APPLICATION BY HIGHWAYS ENGLAND FOR AN ORDER GRANTING DEVELOPMENT CONSENT FOR THE A303 SPARKFORD TO ILCHESTER DUALLING

SUBMISSION MADE PURSUANT TO DEADLINE 6a

**Application by Highways England for the A303 Sparkford to Ilchester Dualling project
The Examining Authority's written questions and requests for information (ExQ3)
Issued on 25 April 2019**

Drawing Title
**FIGURE 11.5
NOISE LEVELS IN THE DO SOMETHING OPENING
YEAR LA10, 18HR [dB] - SHEET 1 OF 4**

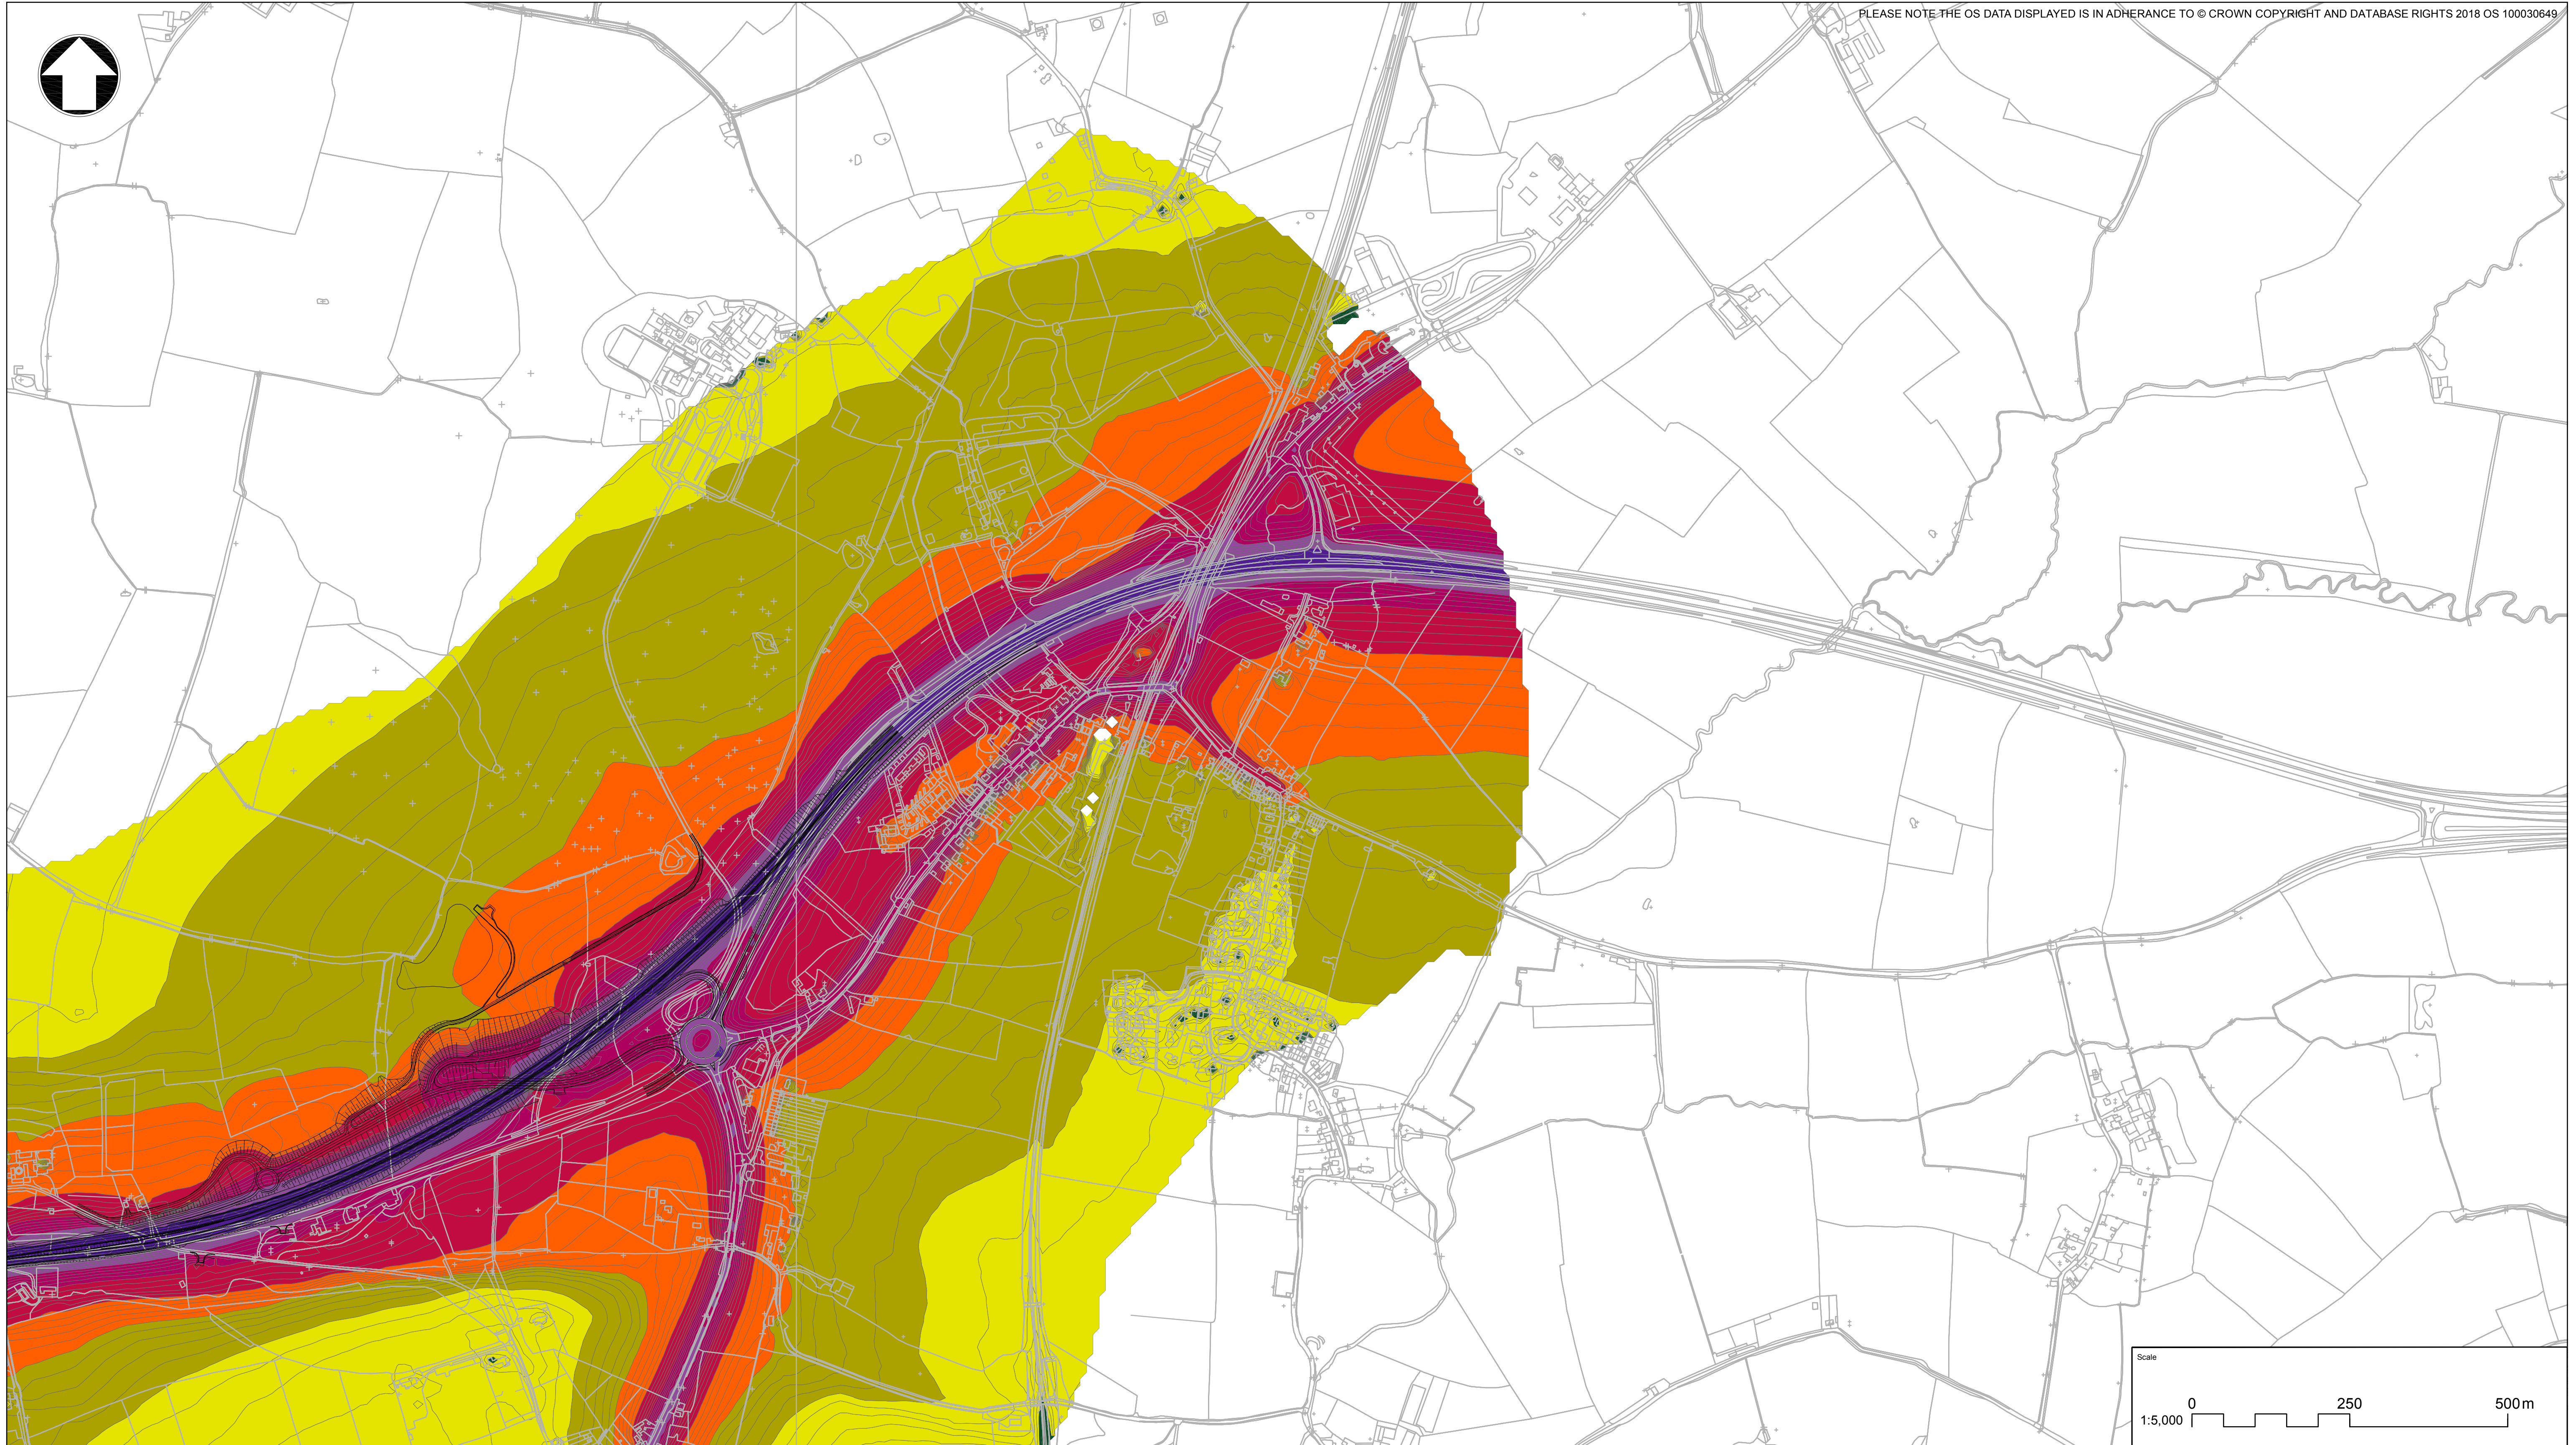
3.4	Noise and Vibration		
3.4.2	The Applicant SSDC	<p>Noise monitoring and Mitigation The ExA appreciates that the applicant's case is that the proposals will not have a significant adverse effect on the local communities in terms of noise.</p>	<p>Figure 11.5 in Chapter 11 Noise and Vibration of the ES confirms that two Noise Sensitive Receptors will be affected adversely – Annis Hill and The Spinney. The applicant is proposing that mitigation in the form of noise bunds and compensation towards secondary glazing and</p>

EXQ3	Question to:	Question:	SSDC Response
		Notwithstanding this, do the parties consider that there is a need to monitor and if necessary, mitigate the noise impacts post construction?	acoustic ventilation. SSDC is satisfied that this mitigation is sufficient to reduce to noise impact to acceptable levels. SSDC considers that it is necessary to monitor this action post construction to ensure that this mitigation has been delivered in line with the applicant's proposals.
